**Application no:** H23-0876-10

**Description:** Proposed replacement dwelling

**Location:** The Bungalow  
Common Road  
Whaplode Drove  
Spalding Lincs  
PE12 0UF  
PE12 0UF

# AMENDMENT RECORD SHEET - LIVE APPLICATION

SECOND FLOOR PLAN

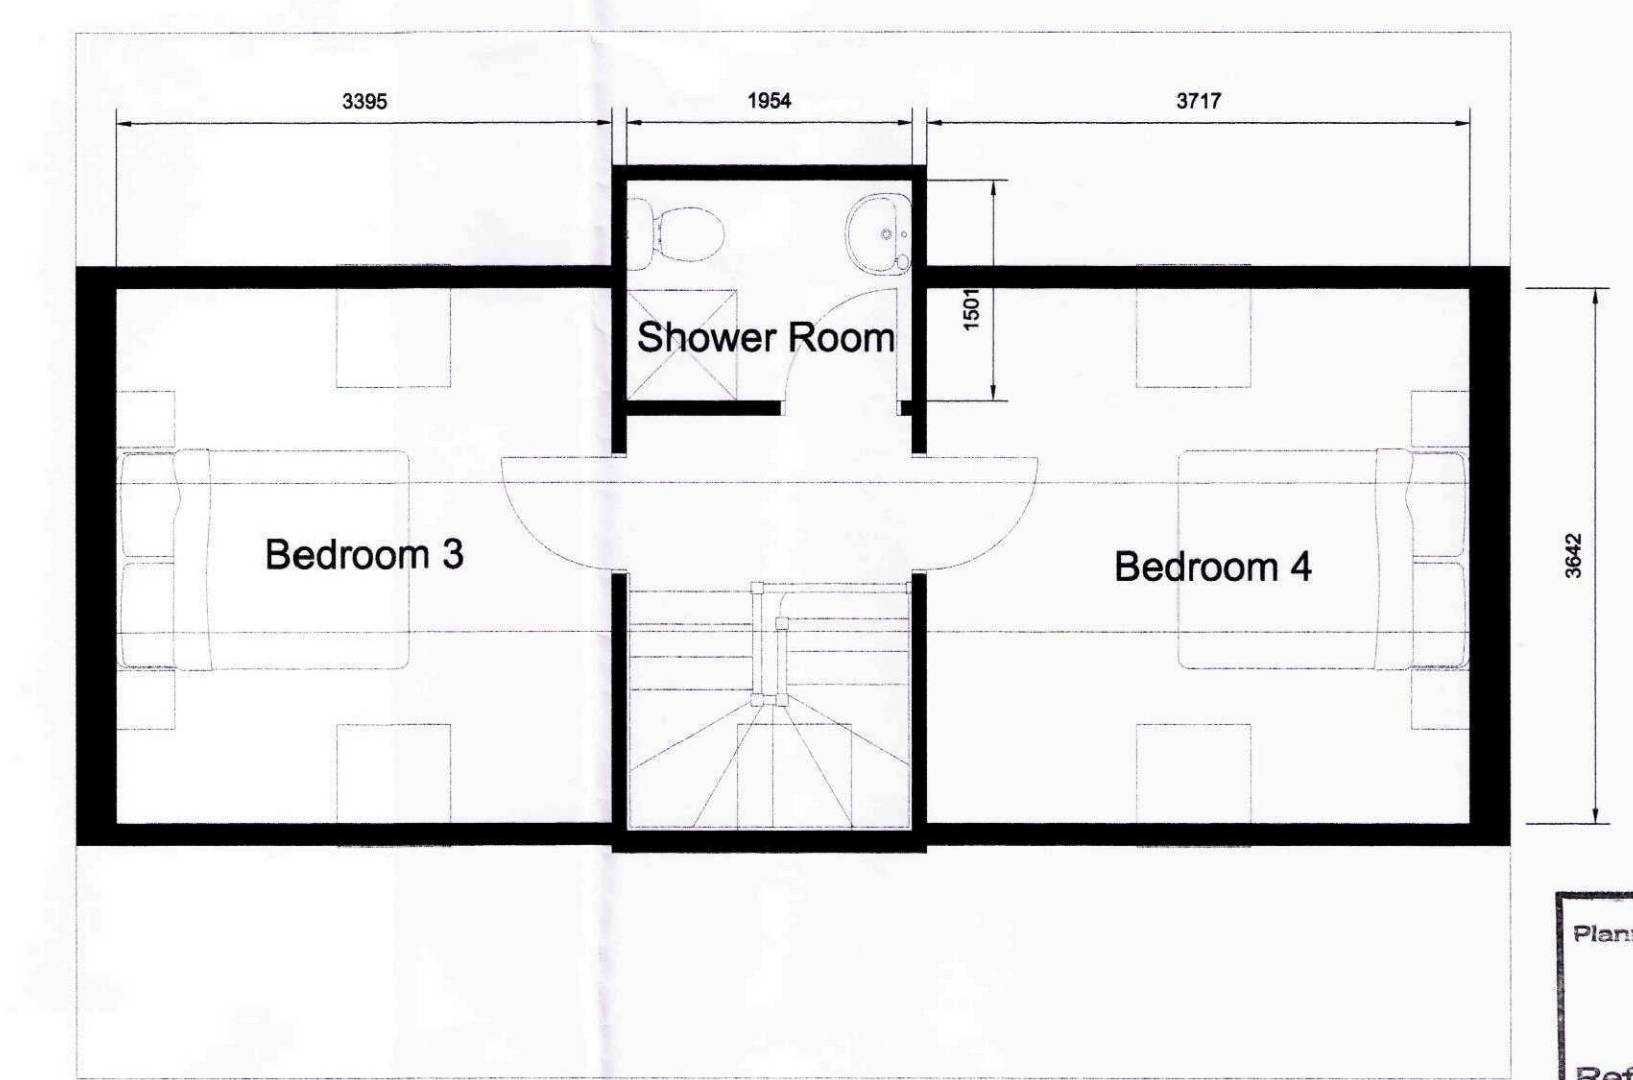
In accordance with the above, a number of revisions are therefore required to make the development more acceptable. The dormer at the rear in particular is unacceptable and should be omitted. The number of rooflights on the front elevation is also excessive - the middle one should be deleted. Whilst we are somewhat more relaxed in respect of the rear elevation, the window on the side elevation should have a greater vertical emphasis.

The external roofing material to be used for the main roof and bays will need to be a traditional material and not concrete.

I have now modified the drawing according to your wishes, and attach a copy for your comments. I believe that I have addressed the dormer issue and have reduced the Velux type windows also, taking them off the front elevation completely. I have added two small windows in the gables and trust that you will not have a problem with these. I have also changed the roof covering specification, and have slimmed down the ground floor gable window.
